Application by Port of Tilbury London Limited for an Order Granting Development Consent for a Proposed Port Terminal at the Former Tilbury Power Station ('Tilbury2')

Issue Specific Hearing on Ecology, Habitats Regulations Assessment, and Traffic and Transportation – Highways England Response

Drawing Title: **GENERAL ARRANGEMENT PLANS ASDA ROUNDABOUT SHEET 5 OF 5 REGULATION 5(2)(o)**

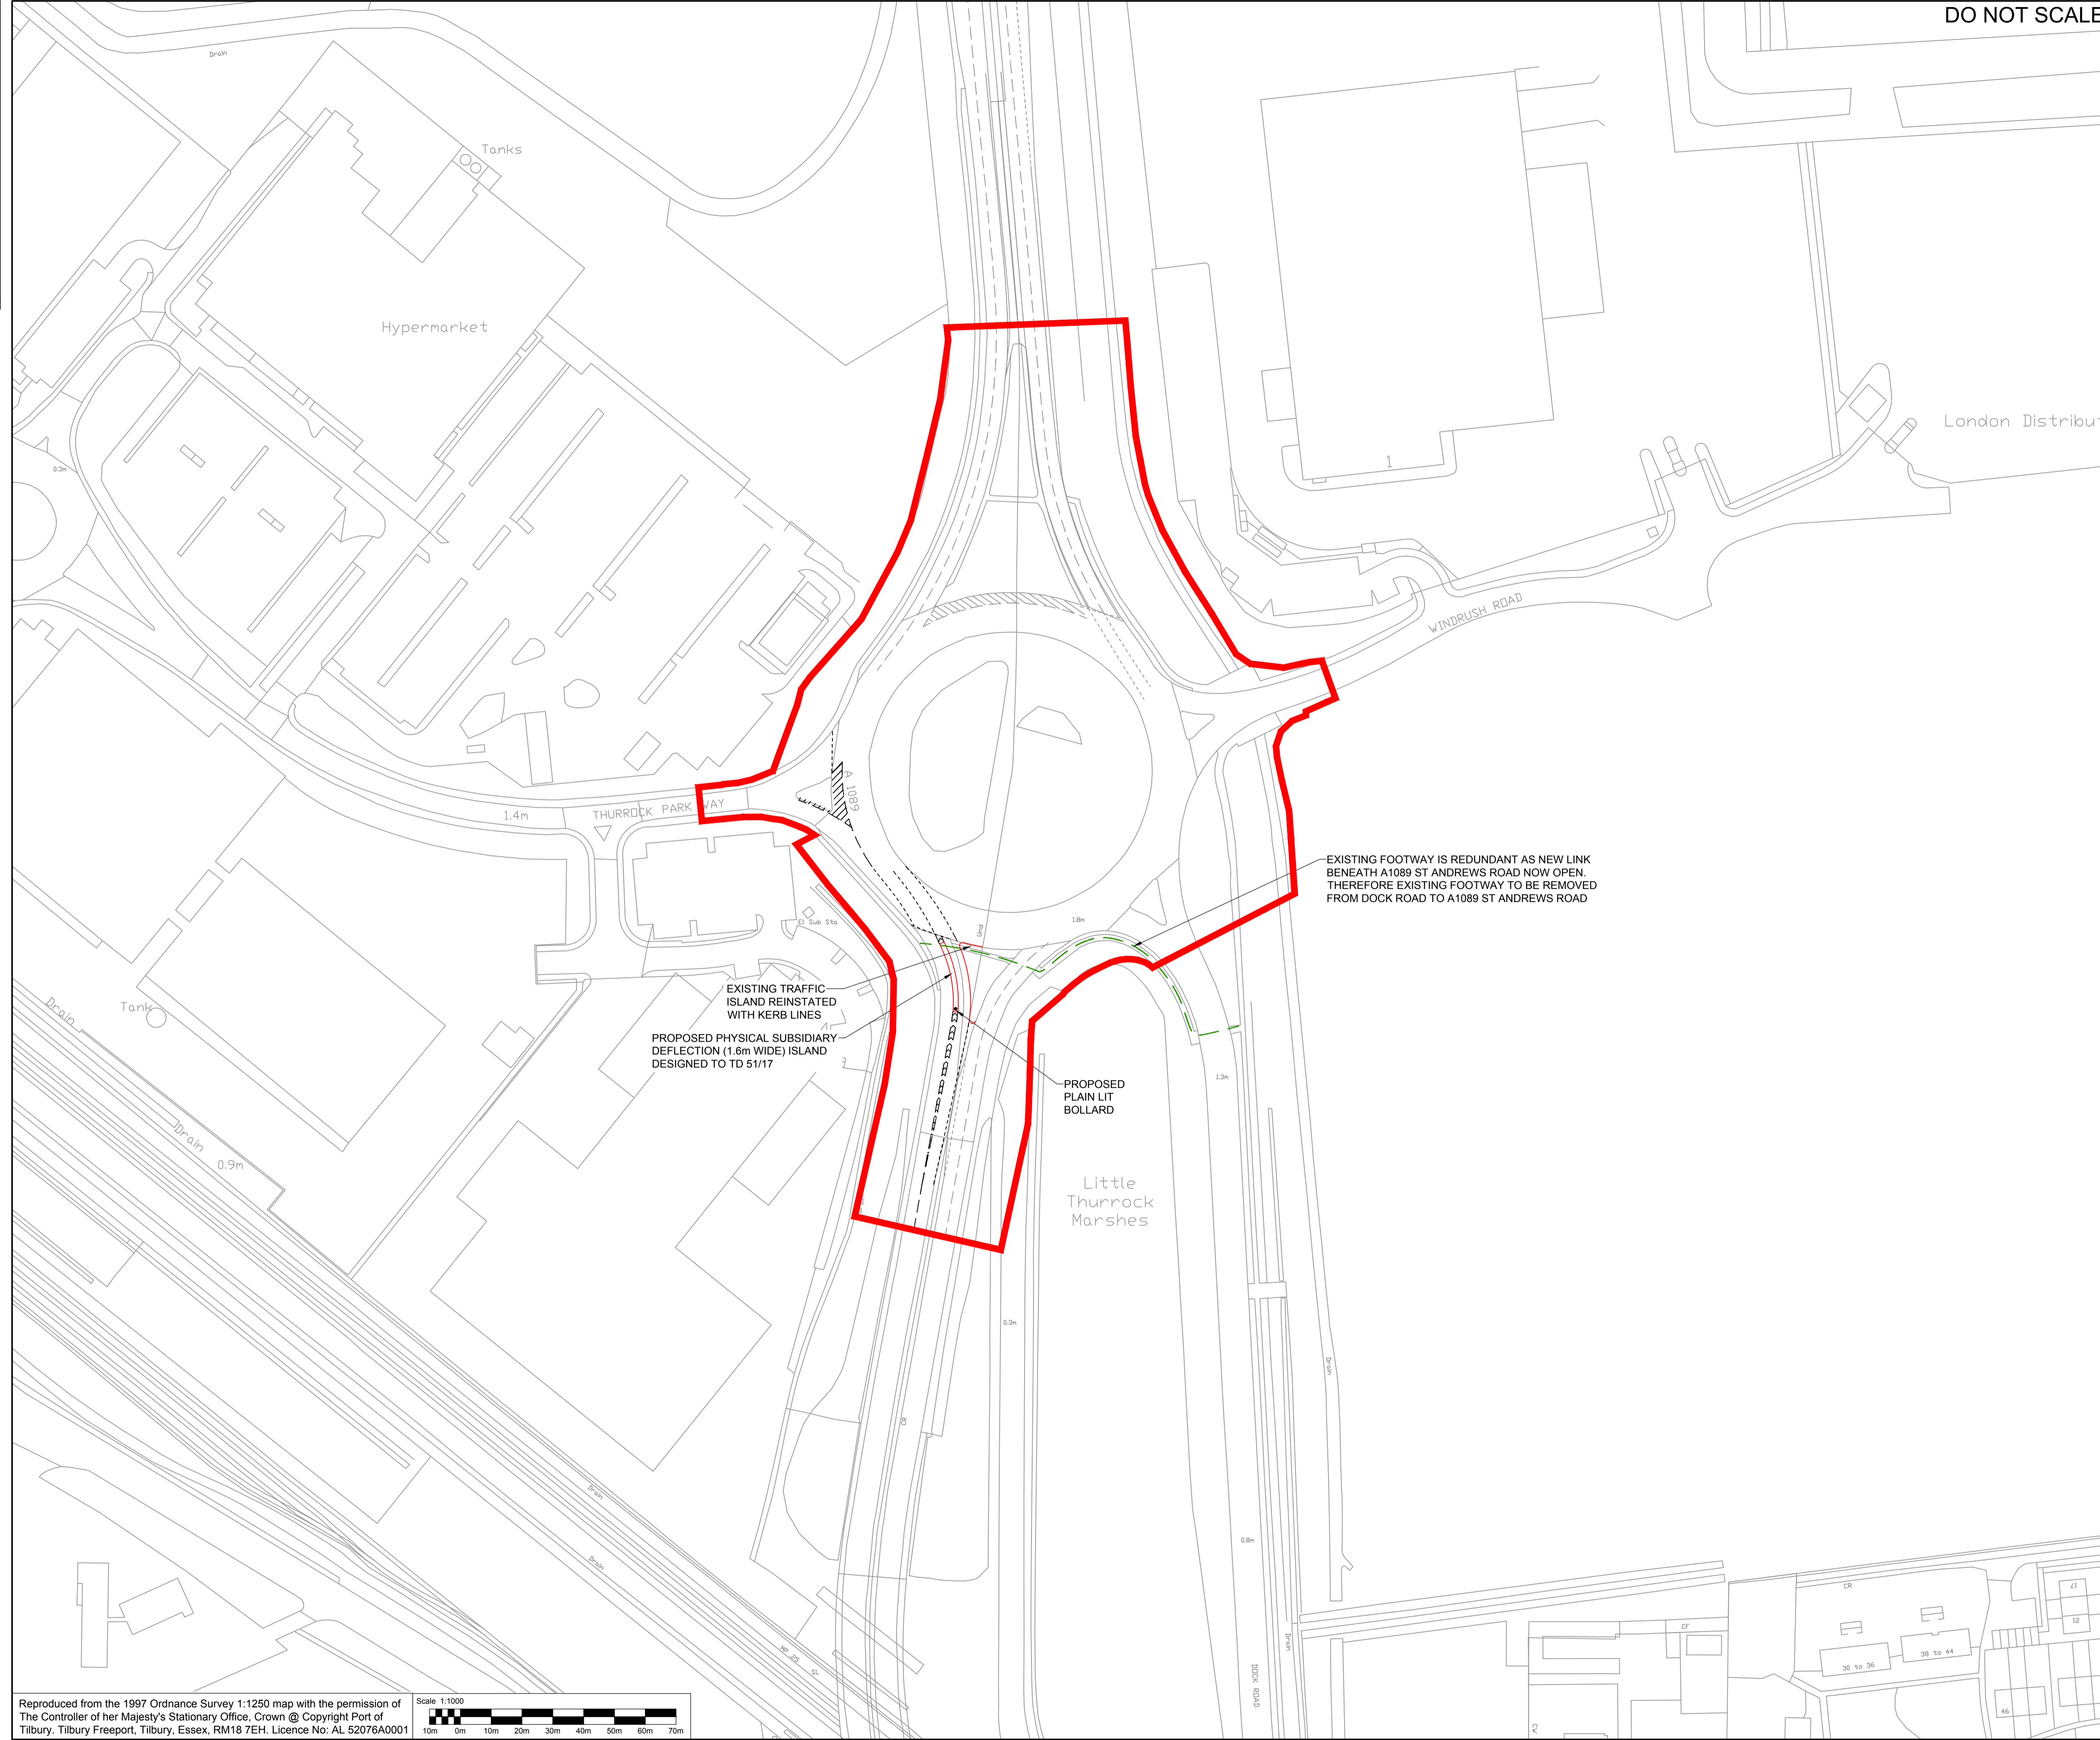
<p>2018 to collaboratively review and amend the proposed mitigation measures at the Asda Roundabout. A scheme of measures to mitigate the impact of the development was agreed in principle. An outline design of the mitigation required at ASDA roundabout has been drawn up by the Applicant and the draft layout has been agreed (by TC and HE) as what is required, subject to the outcomes of HE's design checks and an independent Road Safety Audit. The Applicant has provided traffic modelling results of the revised proposed mitigation. These show operational improvements at the junction and are subject to checking by HE.</p> <p>A significant amount of work is needed before an outline design is agreed and signed off but it may be possible to achieve this by the end of the Examination subject to the design adequately addressing additional traffic from the proposed development. A WCHAR update and as previously mentioned a Stage 1 RSA will also be required to ensure that the proposed mitigation measures meet the required DMRB standards.</p>

<p>On 26 June 2018 Amazon UK Services wrote to the Examination [AS-075] expressing concern at the mitigation proposed by the Applicant to Asda Roundabout. Amazon UK Services were not involved in the discussions of 20 June so it is not possible to say whether the principles agreed then address the concerns of Amazon. However, HE have made direct contact with Amazon's Transport Consultant. Following a telephone conversation with them on the 6th July 2018 HE has sent Amazon the proposed mitigation drawing for the Asda Roundabout and the supporting modelling results summary tables. Amazon's Consultant has agreed to provide HE with flow diagrams showing the changes in flows that they have identified within their representation [AS-075] together with their junction models, subject to agreement with Amazon. Any need to review the principles will further delay agreement on mitigation.</p>
		<p>d) Limiting the traffic entering and leaving the Tilbury2 site during peak periods?</p>	<p>d) The Applicant has rejected any restrictions on traffic entering and leaving the proposed development. It is now for the Applicant to propose a way forward in the event</p>

<p>iii. Responses to Mitigation proposals:</p> <ul style="list-style-type: none">a) Revised mitigation proposals have been drawn up by the Applicant following the site visit and meeting on the 20th June 2018 and have been agreed subject to design checks, an updated WCHAR and a Stage 1 Road Safety Audit. Therefore we are unable to advise the panel on the robustness of the engineering design at this time.b) The design principles agreed on 20th June 2018 provide for maintaining the existing crossings of the A1089 at Asda roundabout and improved lighting and CCTV of the shared pedestrian/cycleway through the underpass to the south of the Asda Roundabout. Signing will be changed to encourage the use of the underpass rather than crossing carriageways.c) Subject to comments from the police and completion of the outline design The Applicant has agreed to reduce the speed limit between the Marshfoot Road Interchange and the A1089 St Andrews Road approach. This will need to be secured as a commitment by the Applicant. These speed restrictions are in
